**WEST SUSSEX COUNTY COUNCIL
STRATEGIC PLANNING CONSULTATION**

SUBJECT: LU/253/14/DOC - Application for approval of details reserved by conditions 8 (surface water drainage), 9 (discharge of water flows), 10 (foul drainage), 17 (Construction Method Statement), 18 (construction compound), 20 (vehicle wheel cleaning), 22 (specification of layout for roads, footpaths, cycleways and parking areas), and 29 (materials and finishes) following a grant of planning permission LU/355/10/.

LOCATION: Courtwick Lane, Land South Of Railway, Littlehampton, BN17 7PD

Drawing Number	4650/2082	Rev.	D
----------------	-----------	------	---

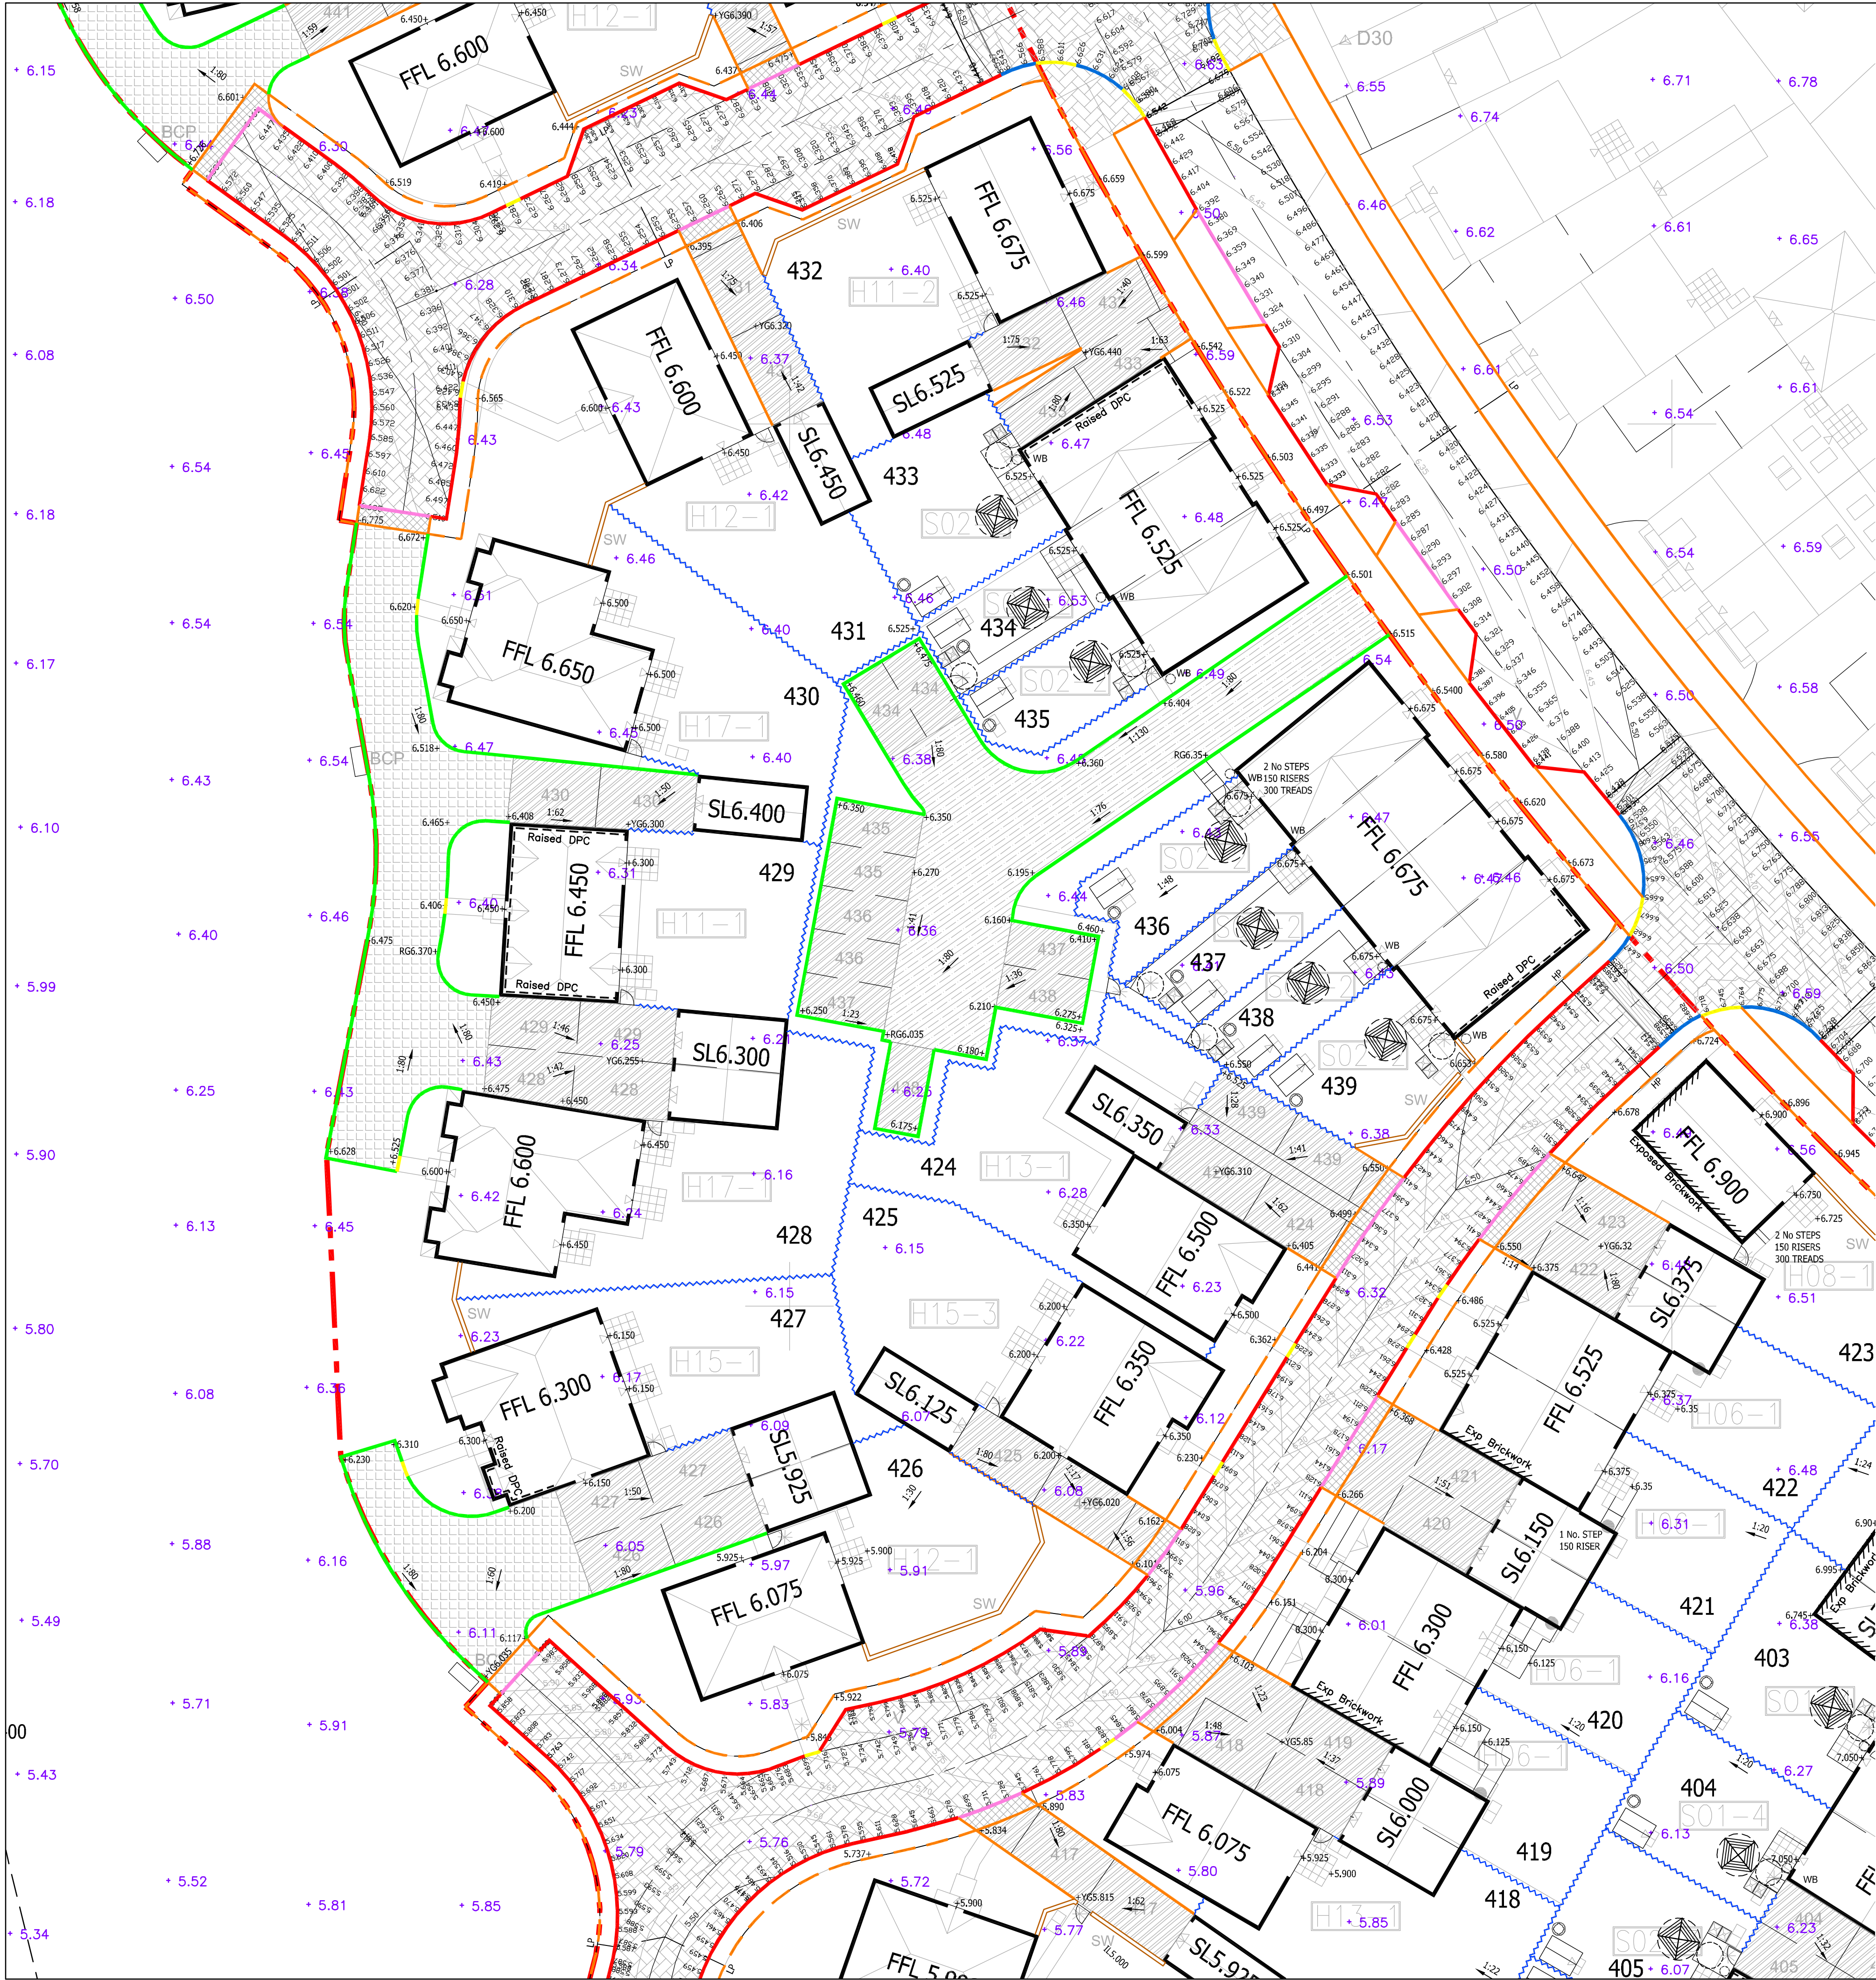
- Where traditional road layout joins shared surface, better delineation should be shown with footways extended just into the shared surface areas.
- Bollards (or similar) should be located on the bellmouth of the raised areas where block paving is currently shown to delineate the pedestrian area (example being adjacent to plot 432).
- Parking spaces for plot 433 appear to be too narrow – please amend to provide correct dimensions.
- Travel distance to/from plots 428 and 429 may exceed 23m for refuse collection.

CONSULTING ENGINEERS glasgow house, 65a church walk, burgess hill, west sussex, rN15 9ds tel 01444 871444 fax 01444 871451 web: www.gtacivils.co.uk				
Drawing Number	4650/2083			Rev.
				D

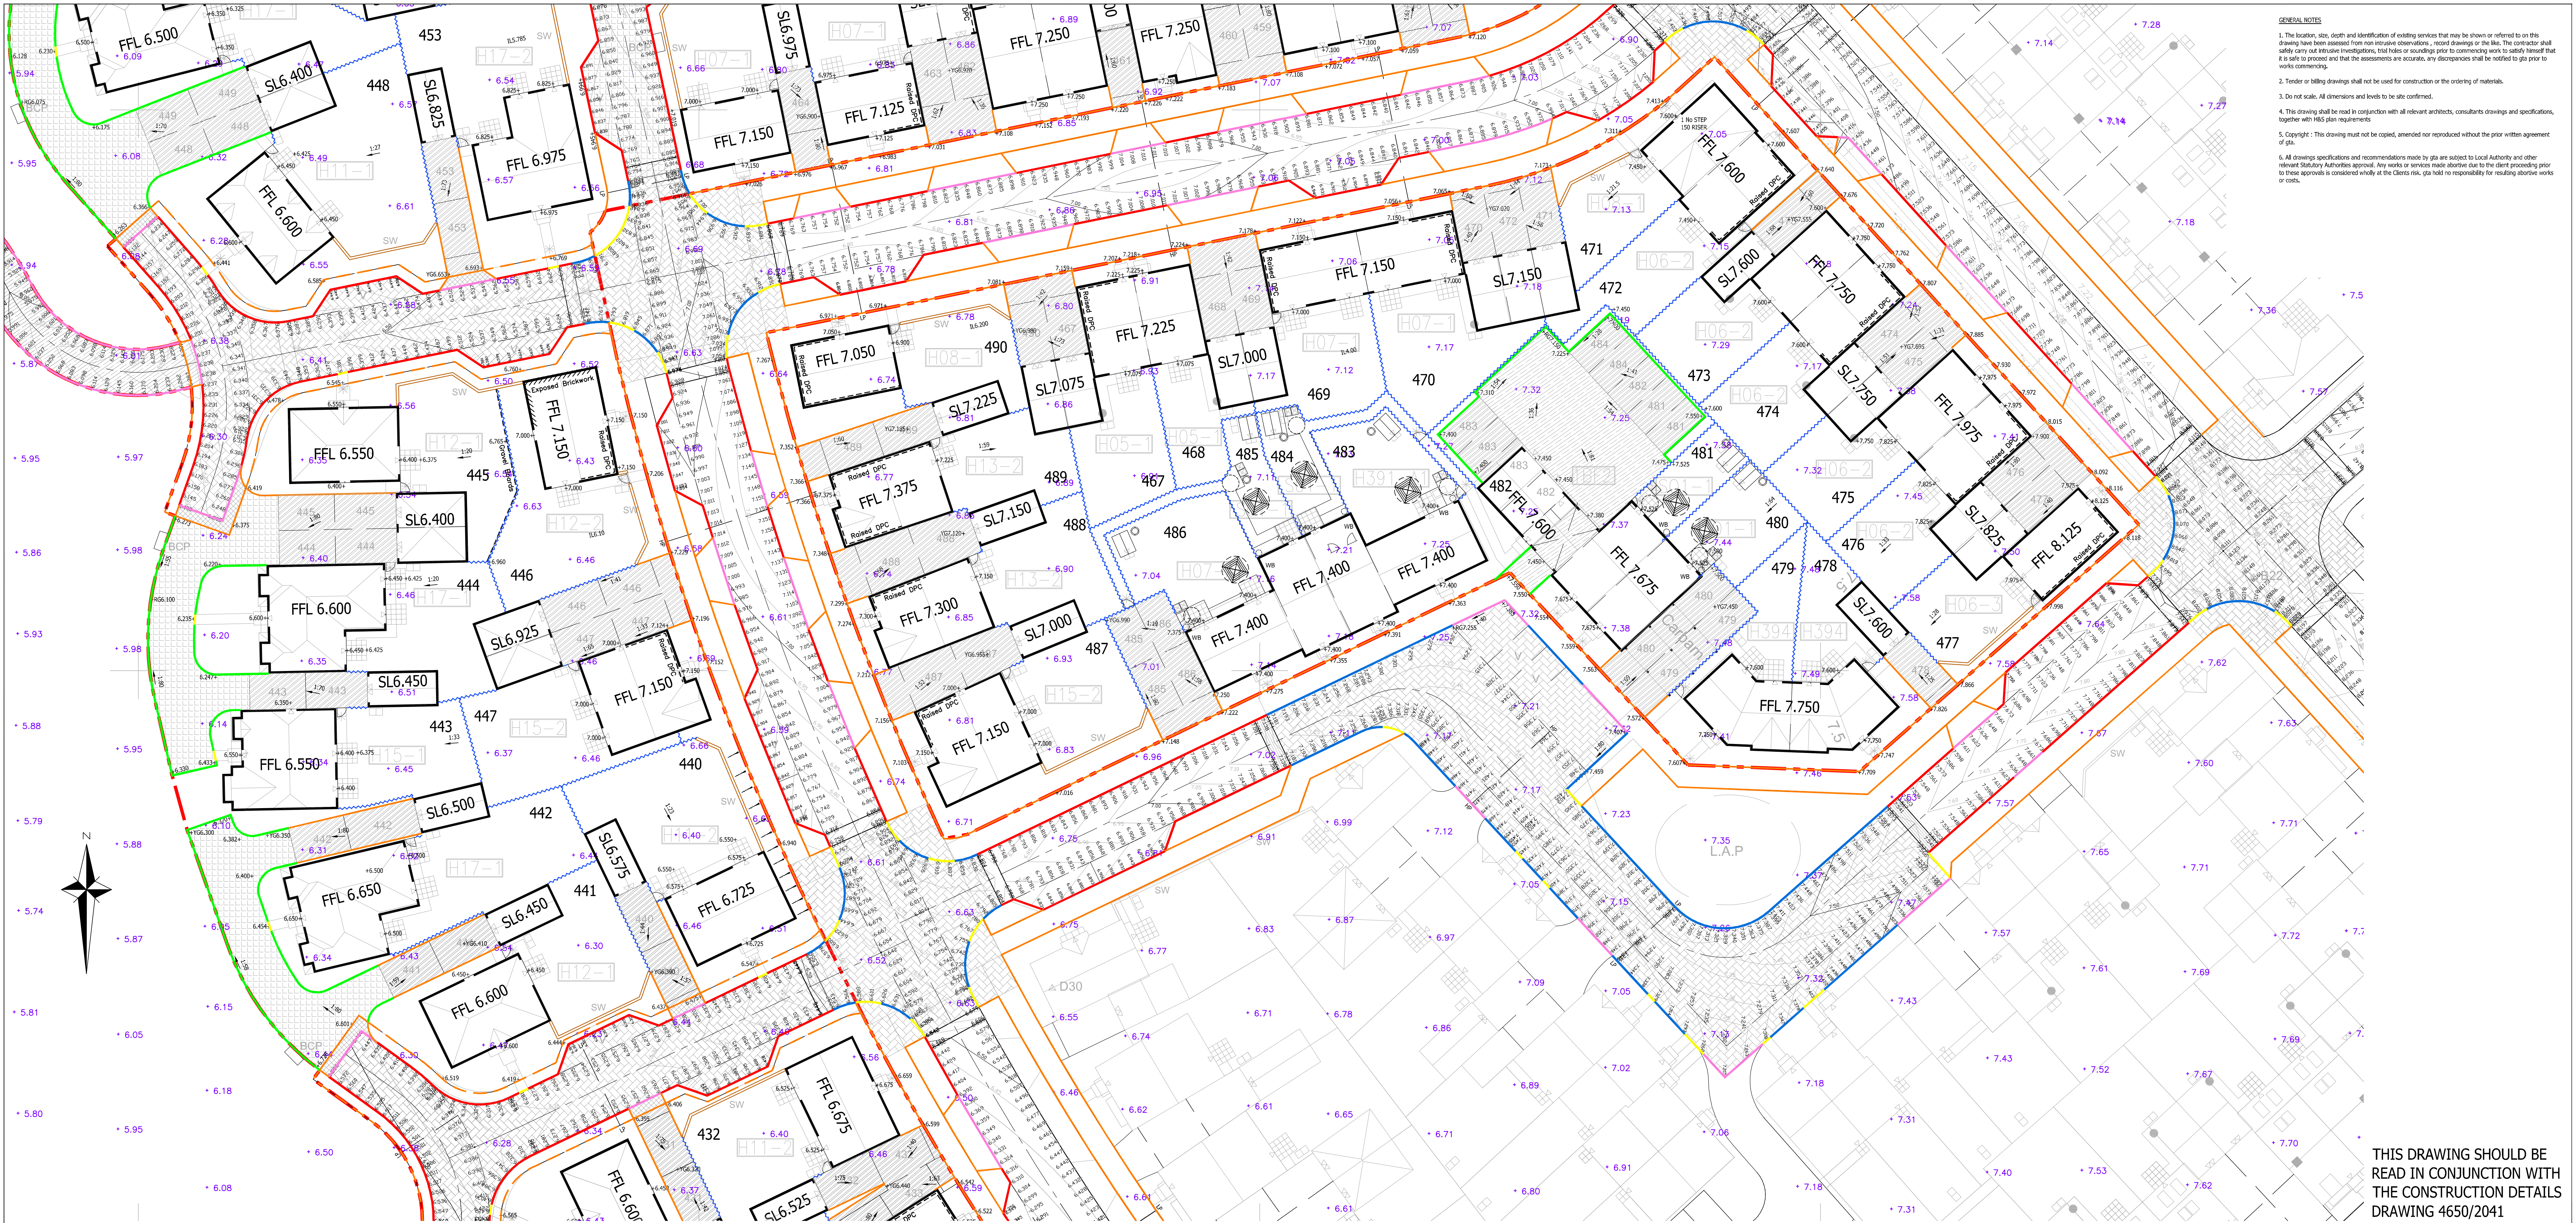
- Where traditional road layout joins shared surface, better delineation should be shown with footways extended just into the shared surface areas.
- Bollards (or similar) should be located on the bellmouth of the raised areas where block paving is currently shown to delineate the pedestrian area (examples being adjacent to plots 446, 490, 453, 440, 487, 432, 471 and 477).
- Short length of remainder of driveways for plots 462-464 might lead to parked vehicles overhanging part of the carriageway – recommend that drives and garages either be moved back or brought nearer to edge of road.
- Length of road running from plot 477 through to 487 creates a mixed message with regard to whether it is a traditional or shared surface road. Further information required here, please.
- Travel distance to/from plot 443 may exceed 23m for refuse collection.
